**Our Case Number: ABP-314724-22**

**An  
Bord  
Pleanála**

**Re:** Railway (Metrolink - Estuary to Charlemont via Dublin Airport) Order [2022]  
Motrolink. Estuary through Swords, Dublin Airport, Ballymun, Glasnevin and City Centre to  
Charlemont, Co. Dublin

I wish to make an objection to the proposed Linear Park design for the Ashley Estate as part of the proposed R132 upgrade project included in the Metro North plans.

Project	Drawing Title	Drawing Status
Estuary - Seatown Landscape Layout Preliminary Design Issue		S4
Drawing N°	ML1-JAI-ARL-SC01_XX-DR-Y-00001	
Scales Original Size A1	1:1000	Sheet 1 of 3

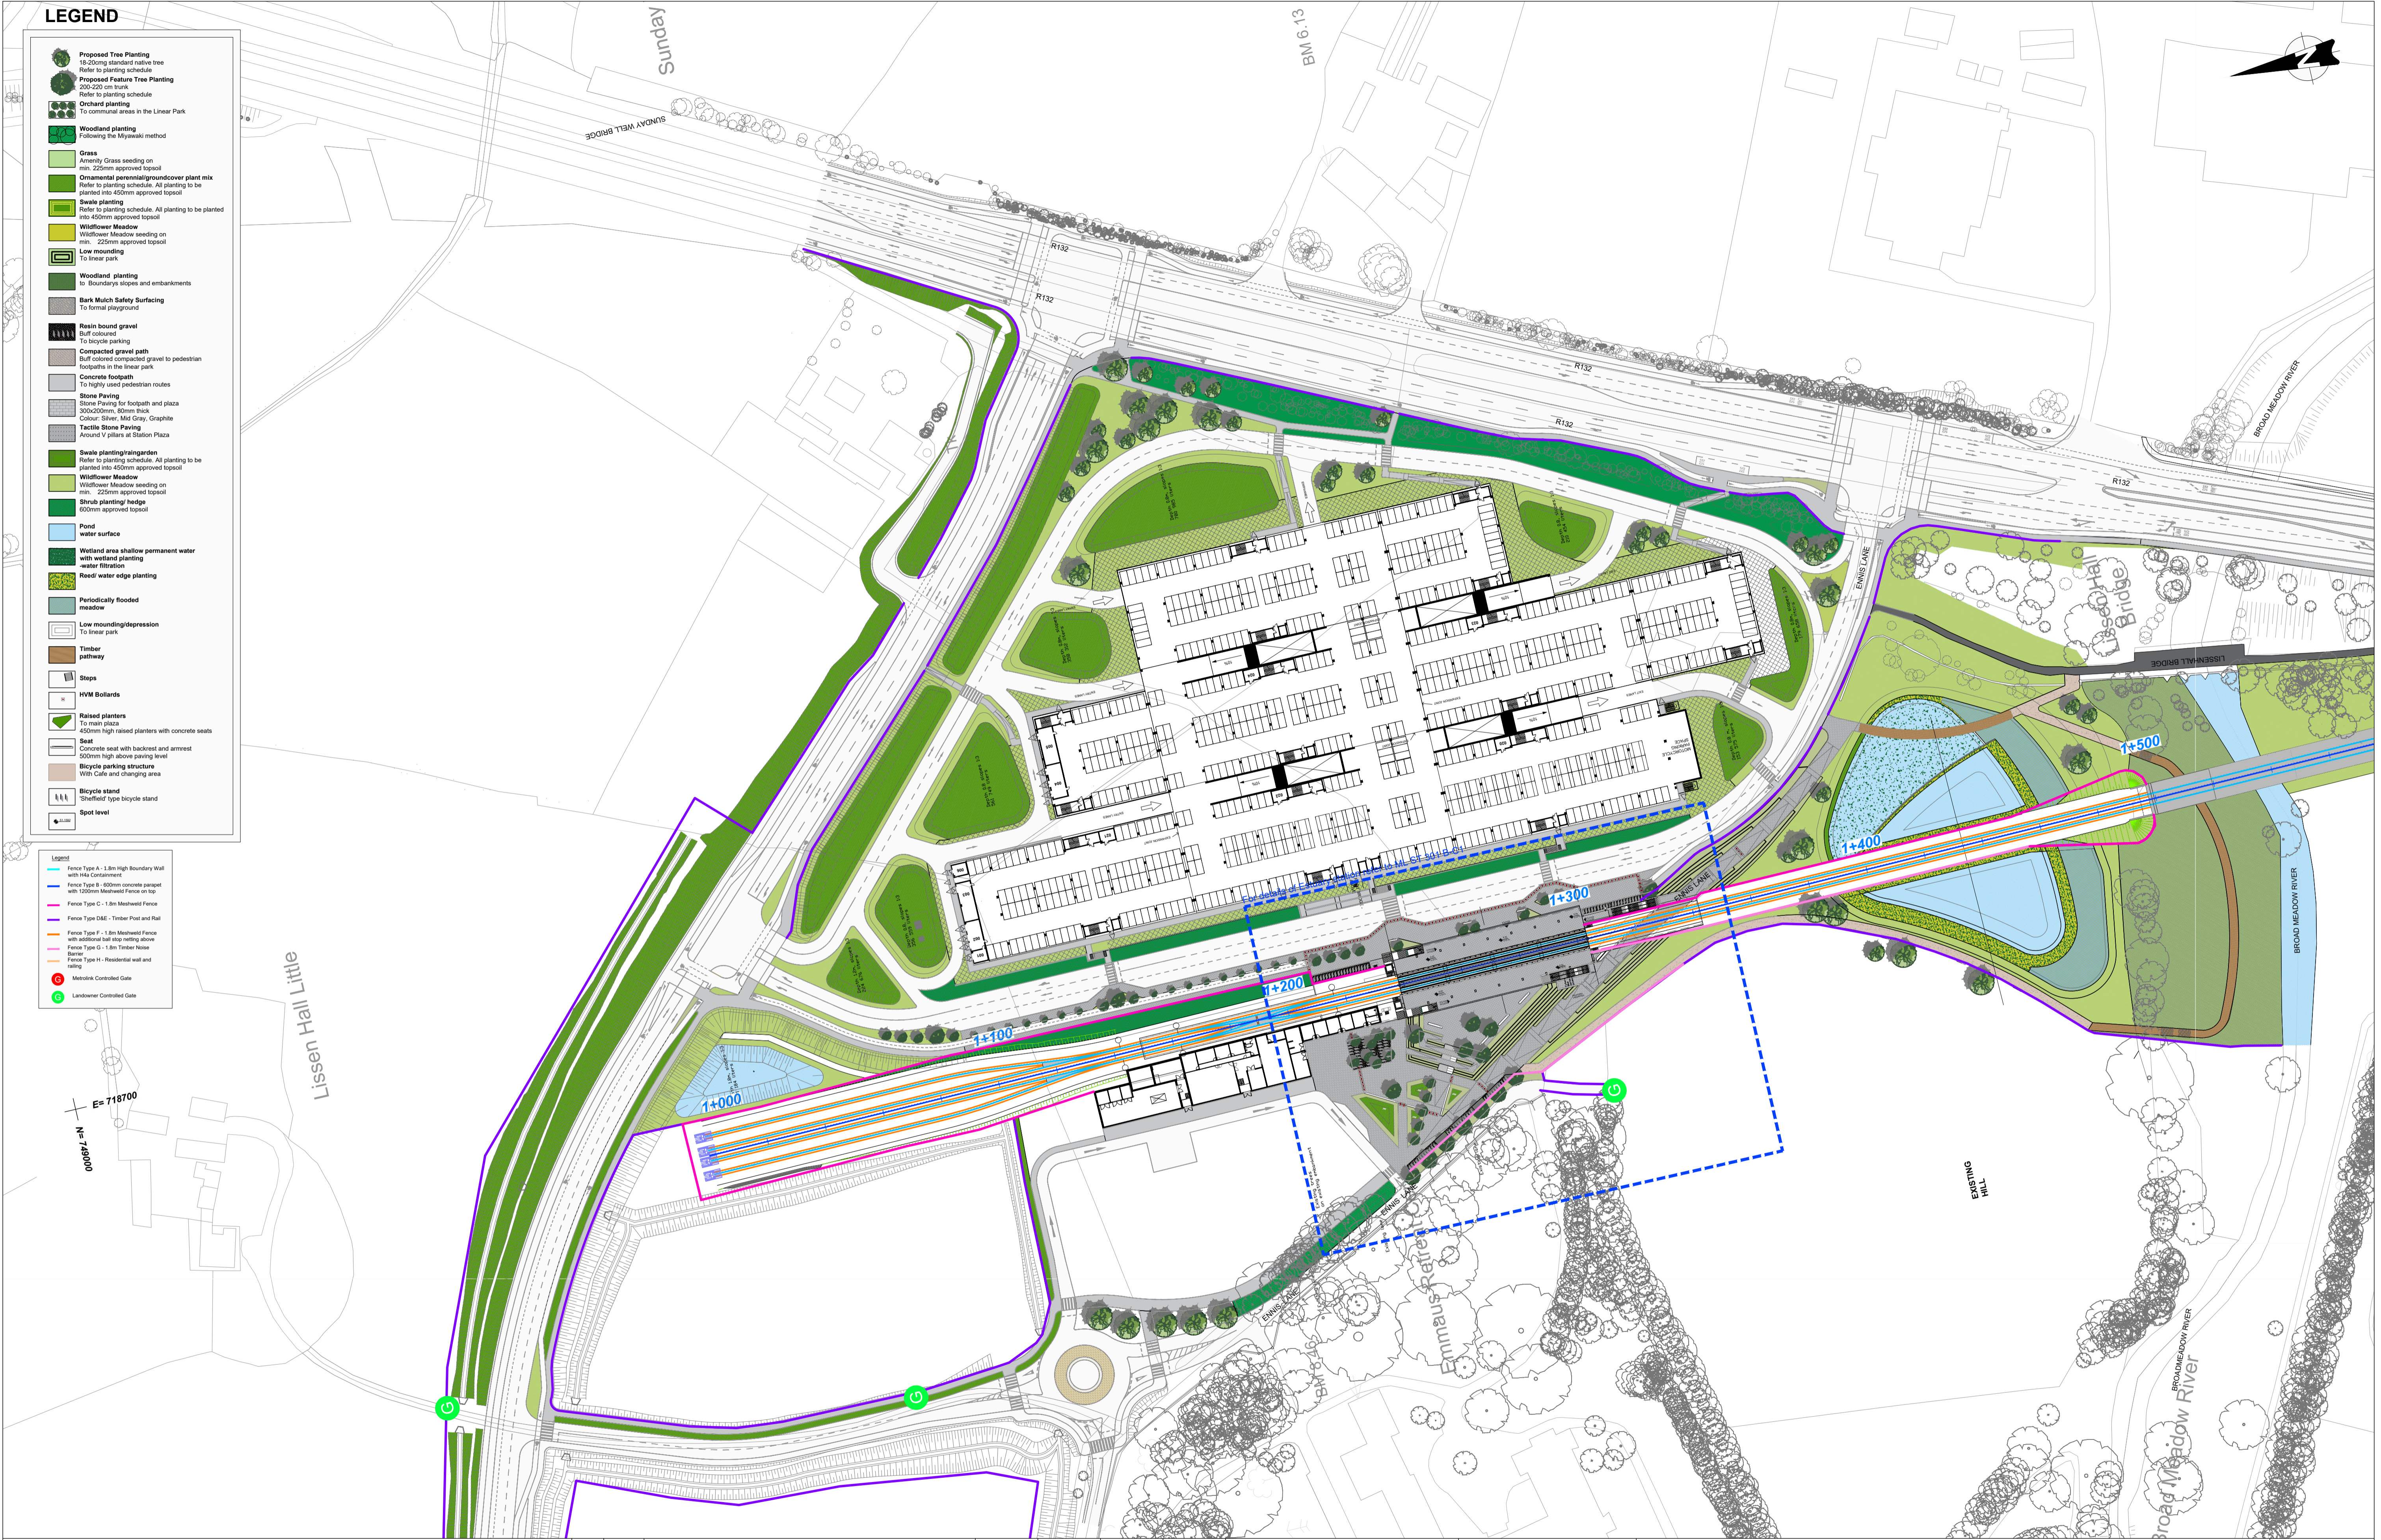
My objections are based on overlooking, loss of privacy, loss of view, loss of security, road safety hazards, loitering and increased noise levels.

Ashley Ave residents will already be seriously impacted by construction of the Metro North which will pass under the Ashley green, less than 30M from our front doors, and to subject us to this linear park proposal which would see us lose our privacy, security and only usable green stretch of space, replaced in stead with zig zag paths several openings directly on to a main road is extremely concerning.

My neighbours and I support the Metro North project however we have stated from the beginning that we would like our green returned to its current state once tunnelling has been completed, with mature trees planted to provide privacy from passing traffic, double decker buses etc. Our support for the Metro North project will be withdrawn otherwise.

My property 38 Ashley Ave marked in yellow above with proposed linear park with several (up to 10?) pathways and openings directly onto main R132 road, low boundary wall with railings on top.
